Application No: AW/1/25/HH
Site Address: 27 Aldwick Avenue Aldwick PO21 3AQ
Description of works: Part single, part two storey side and rear extensions, conversion of garage to habitable use, hip to mansard roof extension with dormers, and alterations to fenestrations.

Thank you for your internet representation made on 4th February 2025 which has been recorded as an objection with the comments as follows:

I object to the development of 27 Aldwick Avenue, for the following reasons.

Site Plan 1:500

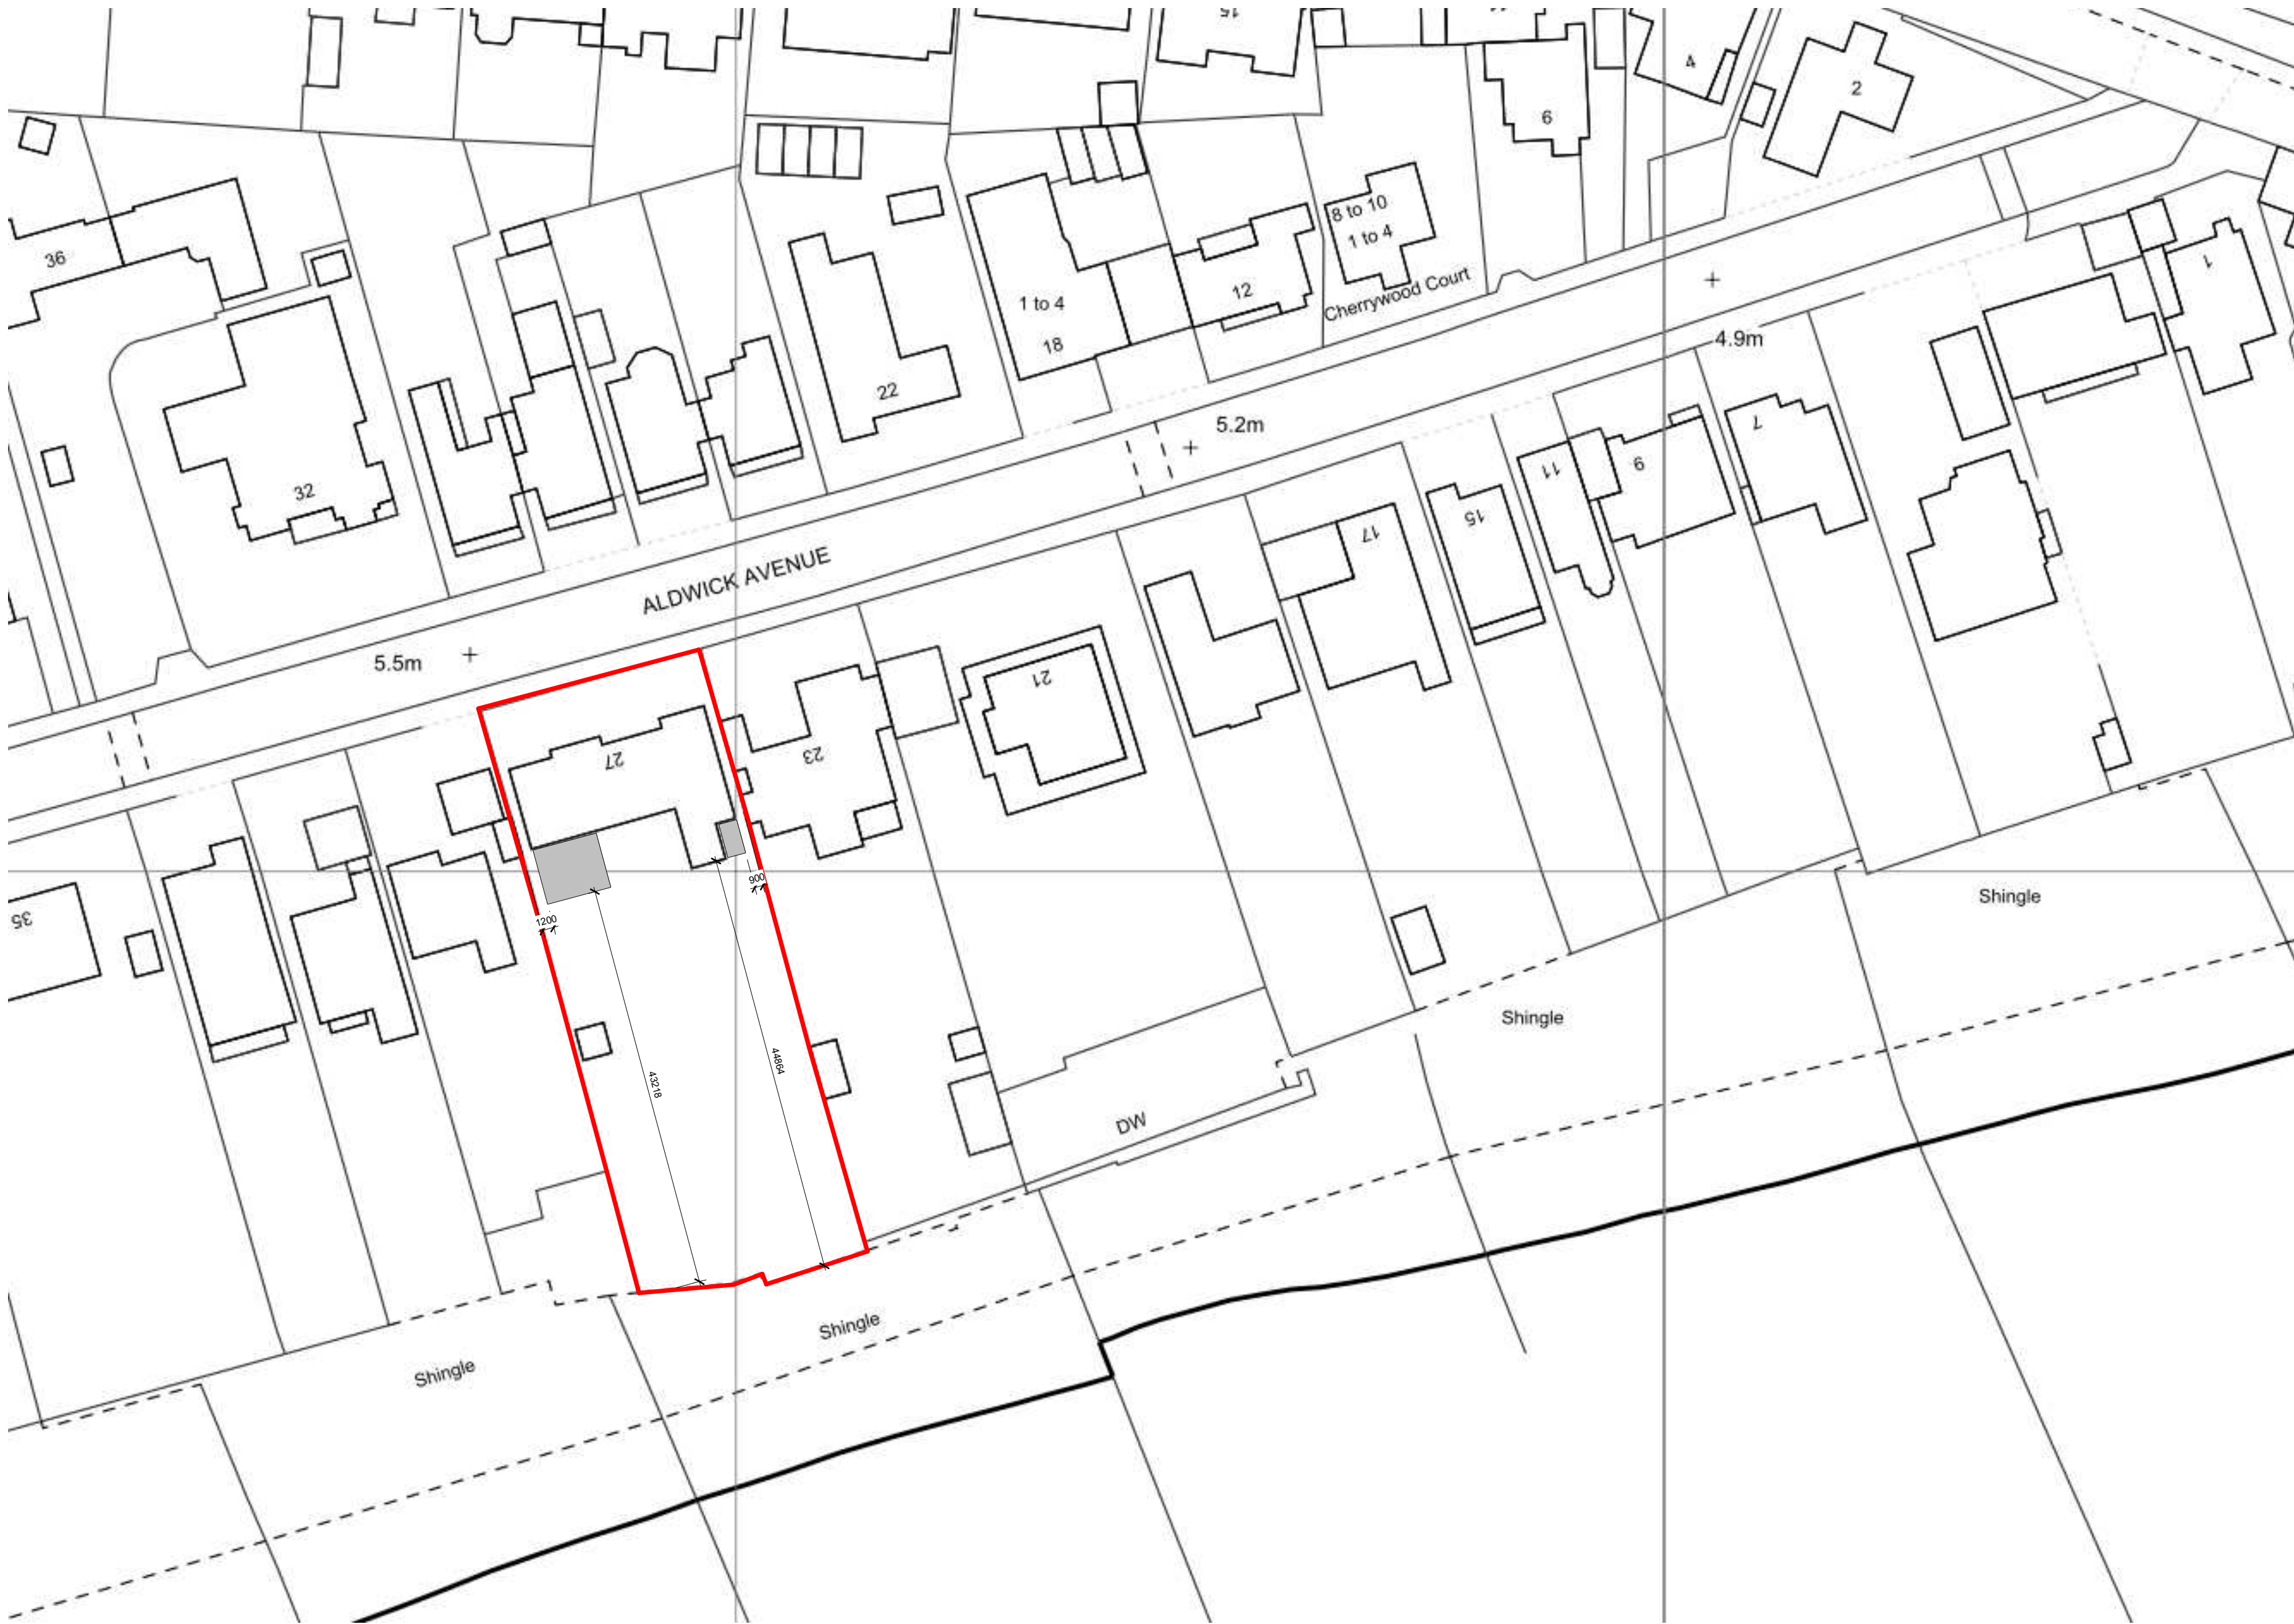
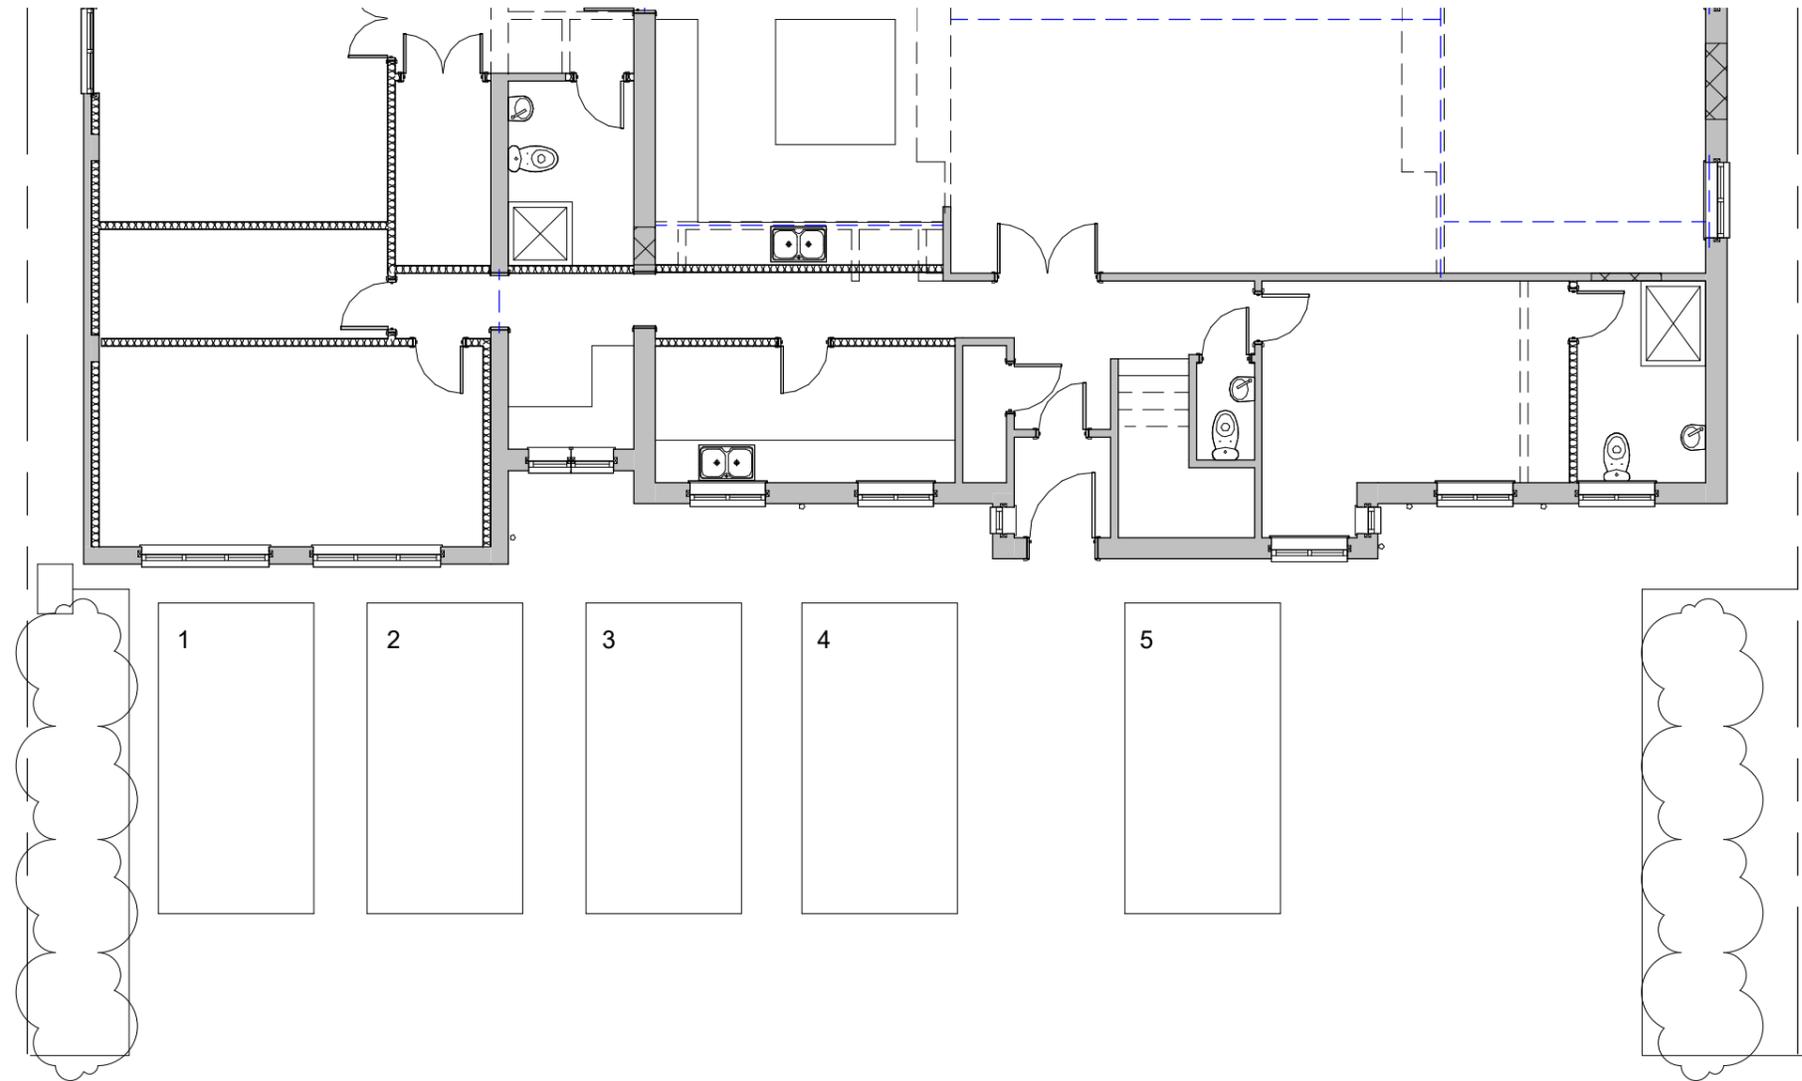
With the size of the proposed building works, there could be up to 5 cars that need to be accommodated, there appears to be no parking within the proposed plans for these cars.
